Subject: Application - 2023/91474 - 94 New North Road

Having considered the submitted details, we offer the following comments.

Proposed Plans and Elevations

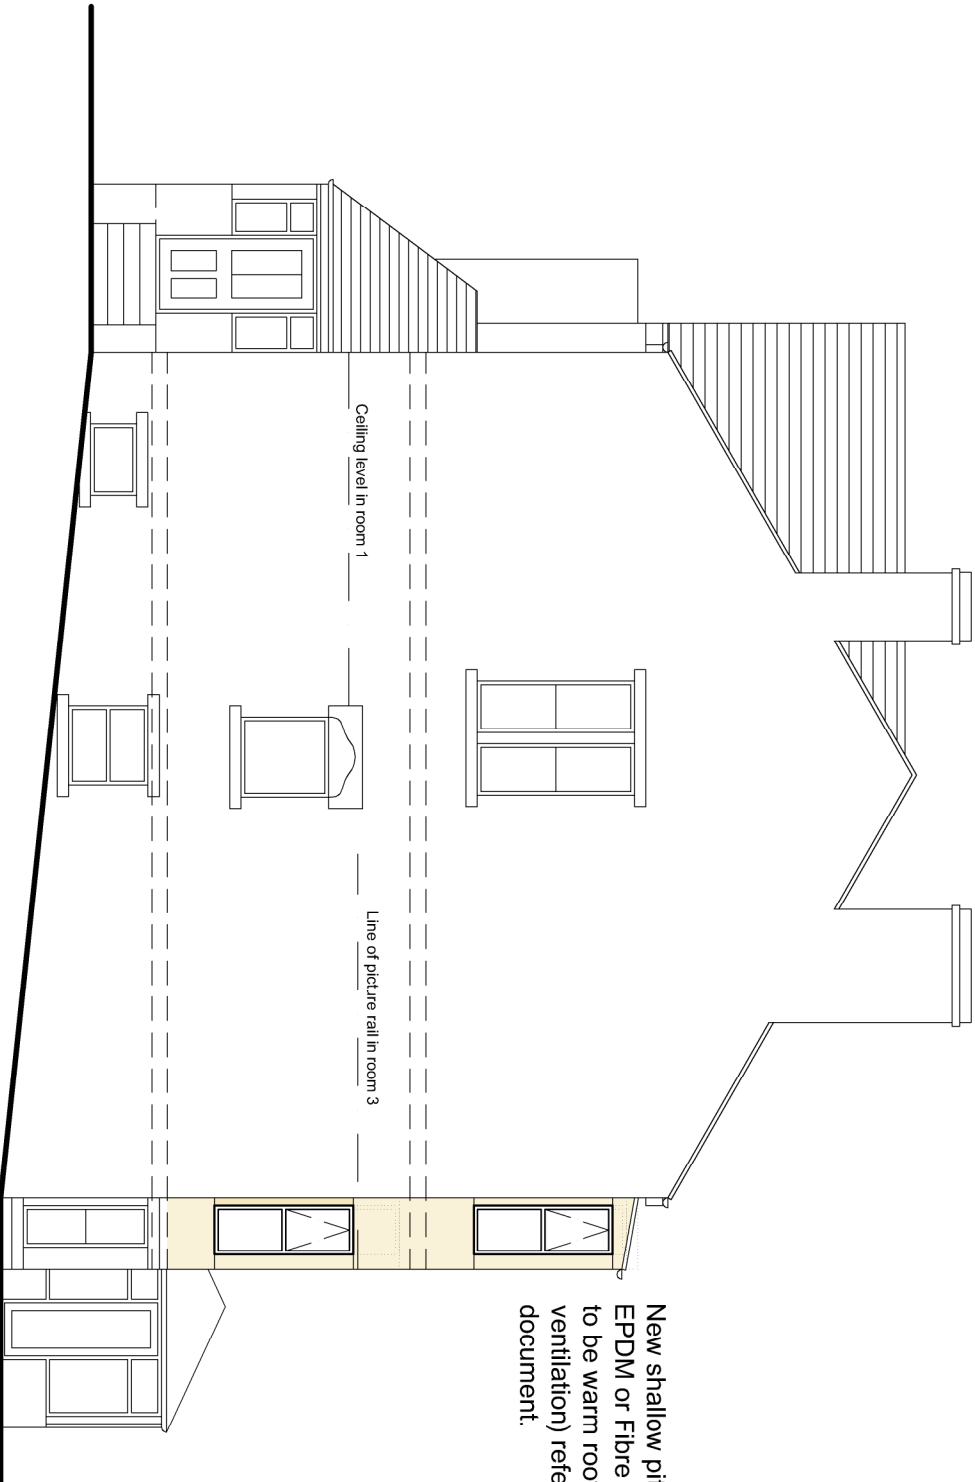
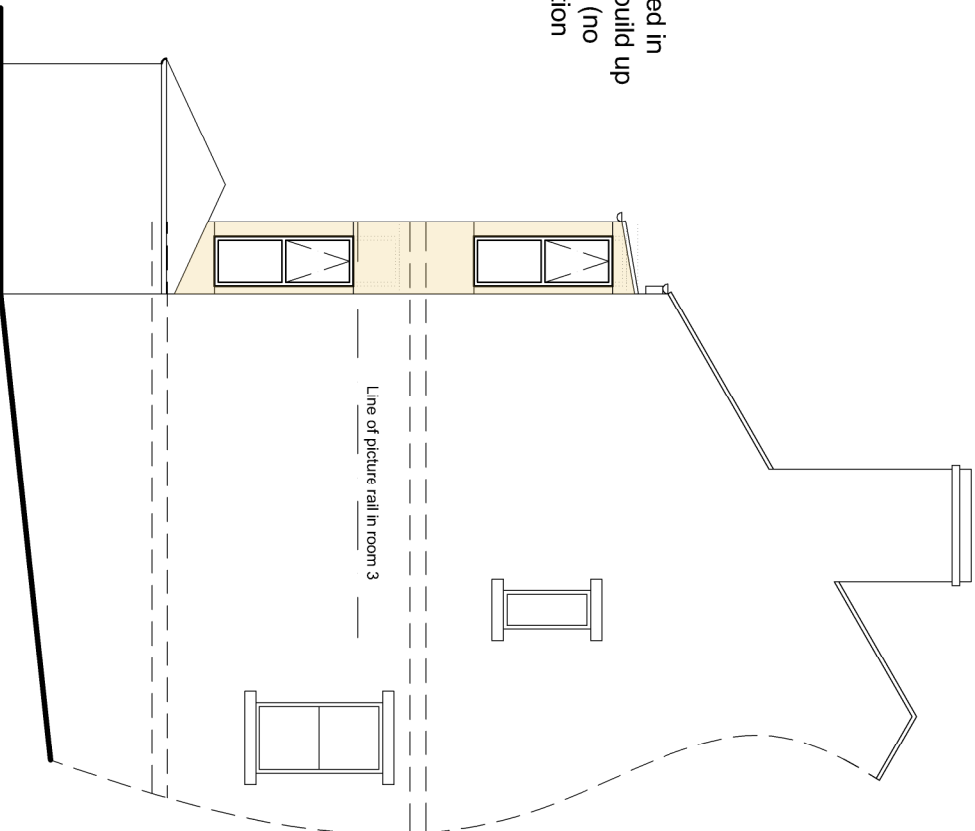
The proposals for the building were located to the rear of the building. Part of the proposal is for the removal of the chimney stack which is located on the side elevation which is the southeastern elevation. We do have concerns in respect of the removal of the stack, while it may be in a poor state of repair, it does form a part of the character of the property and has a positive contribution to the roofscape. We consider that the chimney stack should be retained. If the stack needs to be dismantled and rebuilt, this would be an acceptable approach. We would however reiterate that the stack should be retained.

The remaining elements of the proposals are focused on the rear elevation, the existing window openings, and the central double-height bay window. We do have concerns regarding the proposals. The changes do not appear to affect the windows in the basement, however, there are changes to the ground and first floor. The proposals appear to be seeking to reduce the size of the existing openings, creating more squat window openings. The central double-height bay window is to be entirely altered. We accept that the existing bay window, in terms of materials, is of little merit, being constructed in uPVC, however, the overall form is reasonable. The submission shows that the window openings will again be diminished and there will be a much larger section of what is stated as being Hardie Panels. There are limited details in this regard, however, we are unconvinced by the detail. We consider that while understanding the wish to improve thermal performance, the finish of the windows and bay windows has a negative impact. We consider that the approach needs further consideration, looking to retain the size of the existing openings. We accept the window on the left-hand side to the ground floor could be slightly reduced from its existing size, this would however need to better reflect the detail of the

existing window openings, which would reinstate some of the lost symmetry.

On a side note, we would also set out that while there is a focus on improving thermal performance, the current approach does appear to not be a holistic approach and there is a greater risk of creating a cold bridge. We note the use of trickle vents. While accept the wish to meet building regs, given the building is within the Conservation Area and immediate setting of the noted listed buildings, we consider that trickle vents should be resisted, or need to be a discreet and reduced trickle vent.
